DELEGATED HOUSEHOLDER DECISION

Item No.	Report of the Head of Development Management and Building Control	
Address:	21 WHITTINGTON AVENUE HAYES	
Development:	Erection of a single storey rear extension, a part single part two storey side extension following demolition of existing garage and front porch.	
LBH Ref Nos:	77510/APP/2023/3472	
Drawing Nos:	DR-00008-04 DR-00008-01 DR-00008-02 DR-00008-03 DR-00008-05 DR-00008-06 DR-00008-07 DR-00008-08	
Date Plans received:	01-12-23	Date(s) of Amendments(s):
Date Application valid	01-12-23

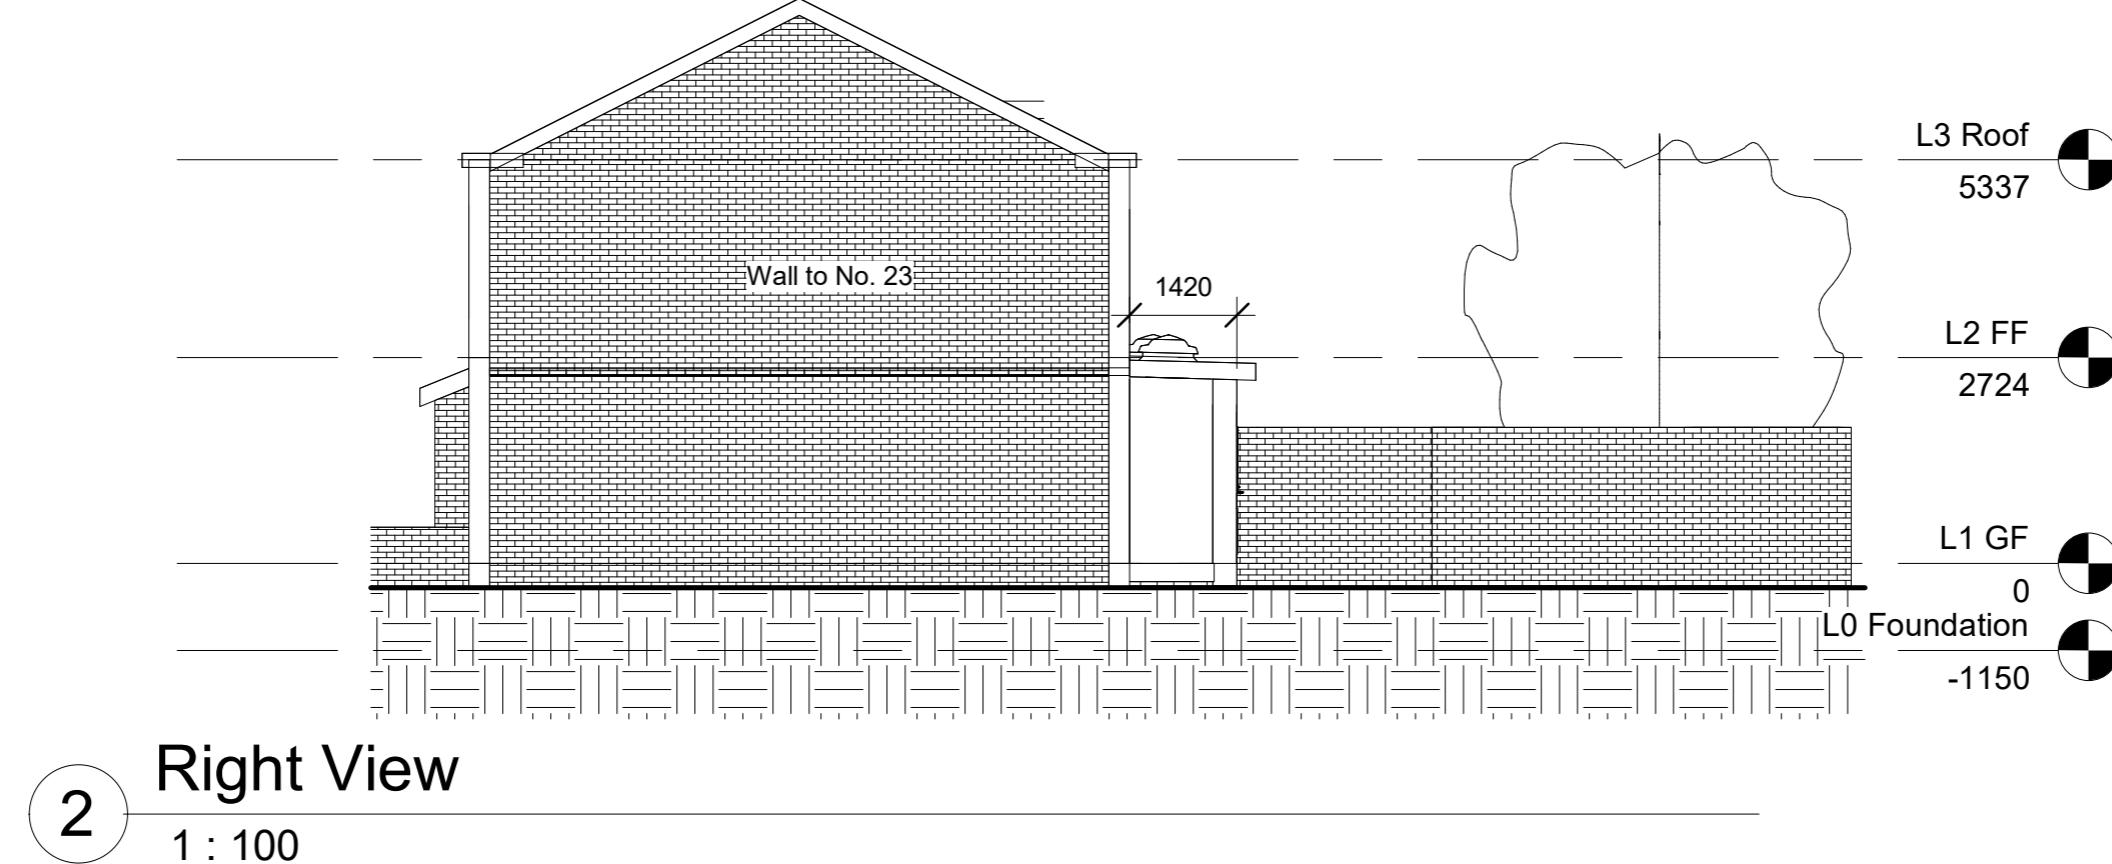
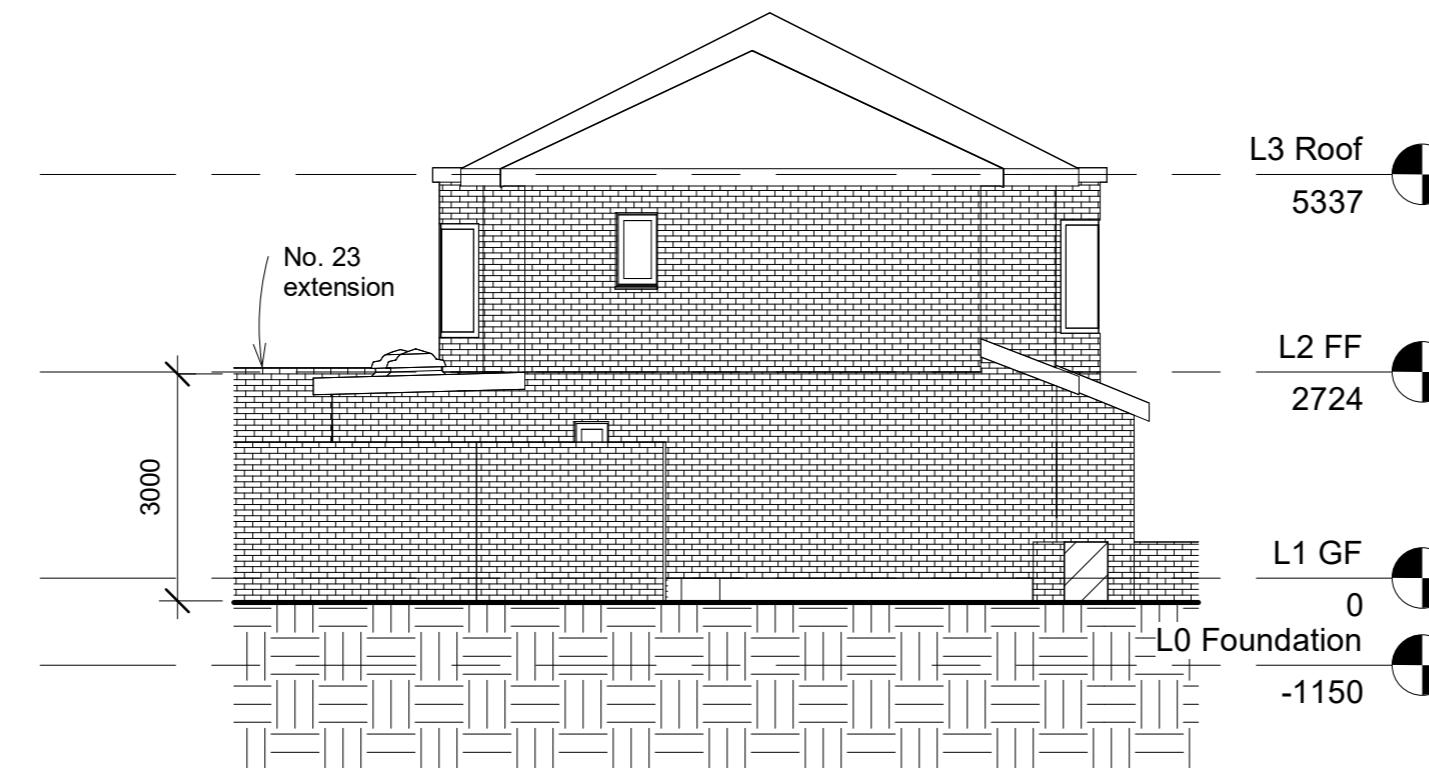
The proposed side extensions do not comply with the requirements of policy DMHD1 as listed above. The side extension would fill the space between the flank wall of the property and the boundary. Given the location of the site, towards the corner, with adjacent property at Number 19 being set forward, the scale and design of the extension to the side would result in the loss of an important gap in the streetscene at first floor level.

The proposed extensions to the side by reason of their siting, scale, bulk and design would fail to read as a subordinate addition to the house and respect its architectural integrity. Given the prominent position of the site in close proximity to the corner plot, the side extension would also result in the closing of an important gap characteristic to the area, fail to respect the established return building line and overall result in harm the established character and appearance of the area. The proposal would therefore represent an overdevelopment of the site to the detriment of the visual amenities of the street scene and the surrounding area, all contrary to Policies DMHB 11 and DMHD 1 of the Hillingdon Local Plan: Part Two - Development Management Policies (January 2020).

Number 19 Whittington Avenue is an end terraced dwelling located to the south of the application site. This property is set forward and has been extended to the side by way of a single storey side extension. Given the degree of separation and projection, the proposed side extension would not intersect the 45 degree line from the closest first floor window in the rear elevation of adjacent number 19 nor give rise to an unacceptable loss of light and outlook. The proposal includes a side facing window at first floor level, which, in the event of an approvable scheme, could be conditioned to be obscure glazed and fixed shut.

Drawing	Proposed Elevations 2
---------	-----------------------

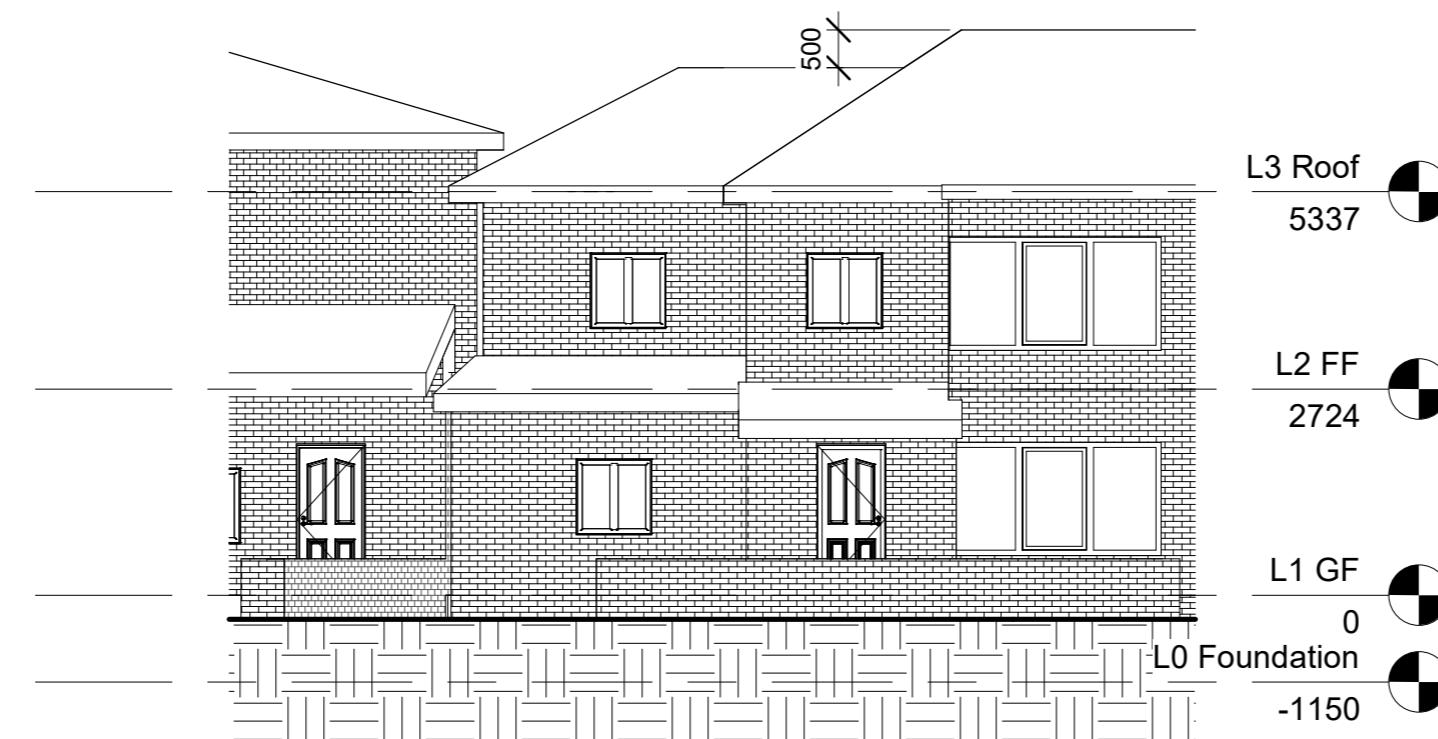
The flat roofed rear extension and front porch are considered acceptable in design terms.

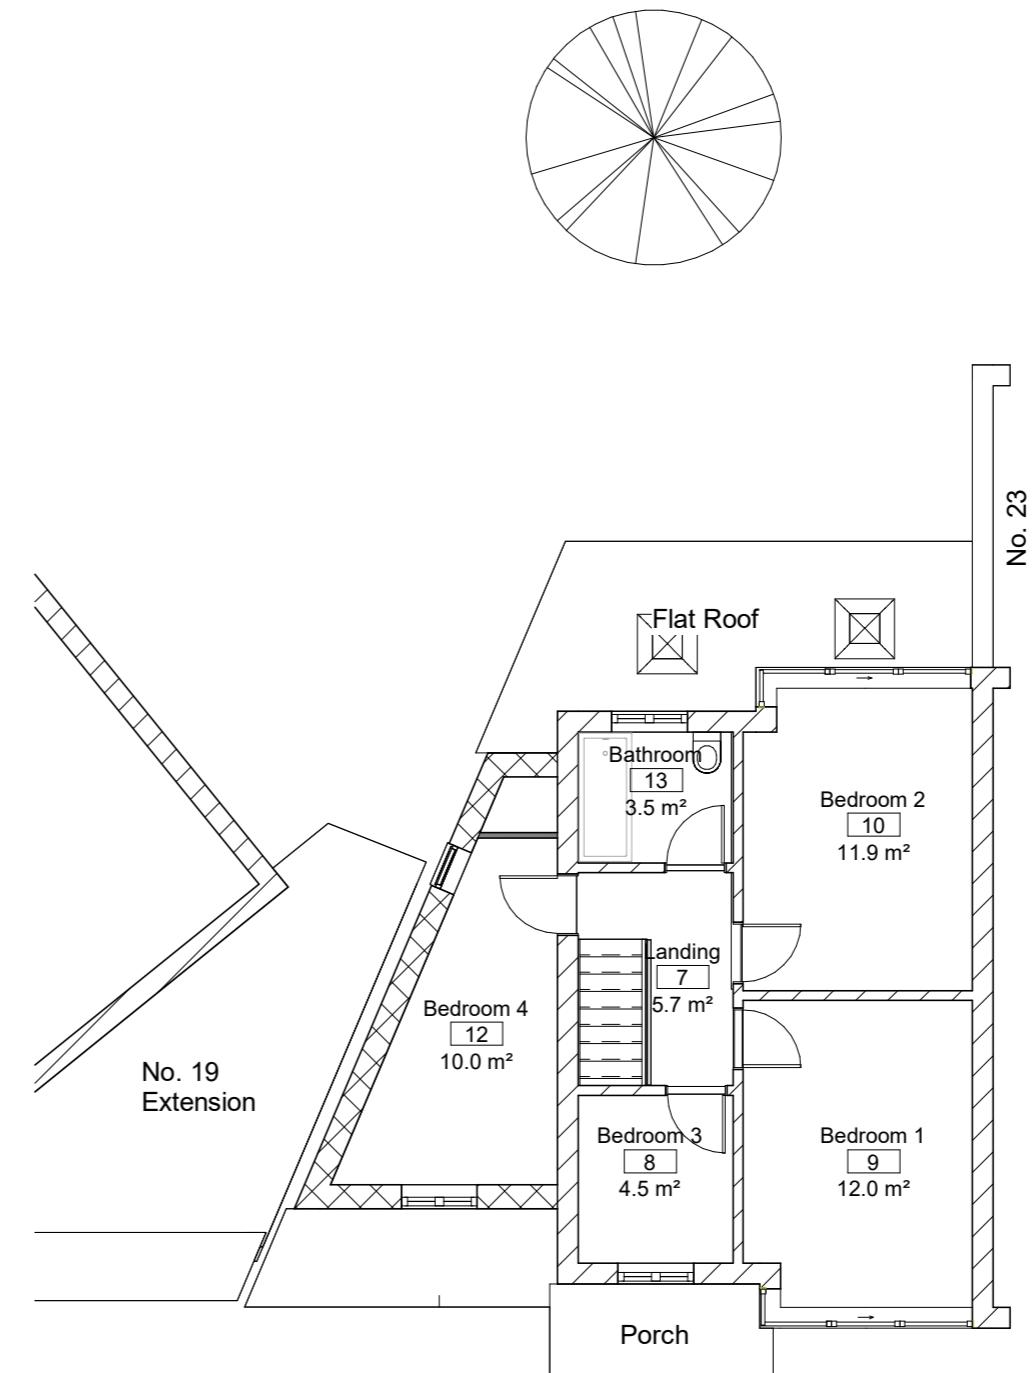
The proposal would result in the creation of a 4 bedroom property. 34 square metres of private rear garden area would be retained which represents a significant shortfall of the 100 square metres required. As such the proposal would fail to fulfill the Part 2 Policy DMHD1 appendix A, Part A) vi), which states that for Alterations and extensions to residential dwellings; adequate garden space is retained.
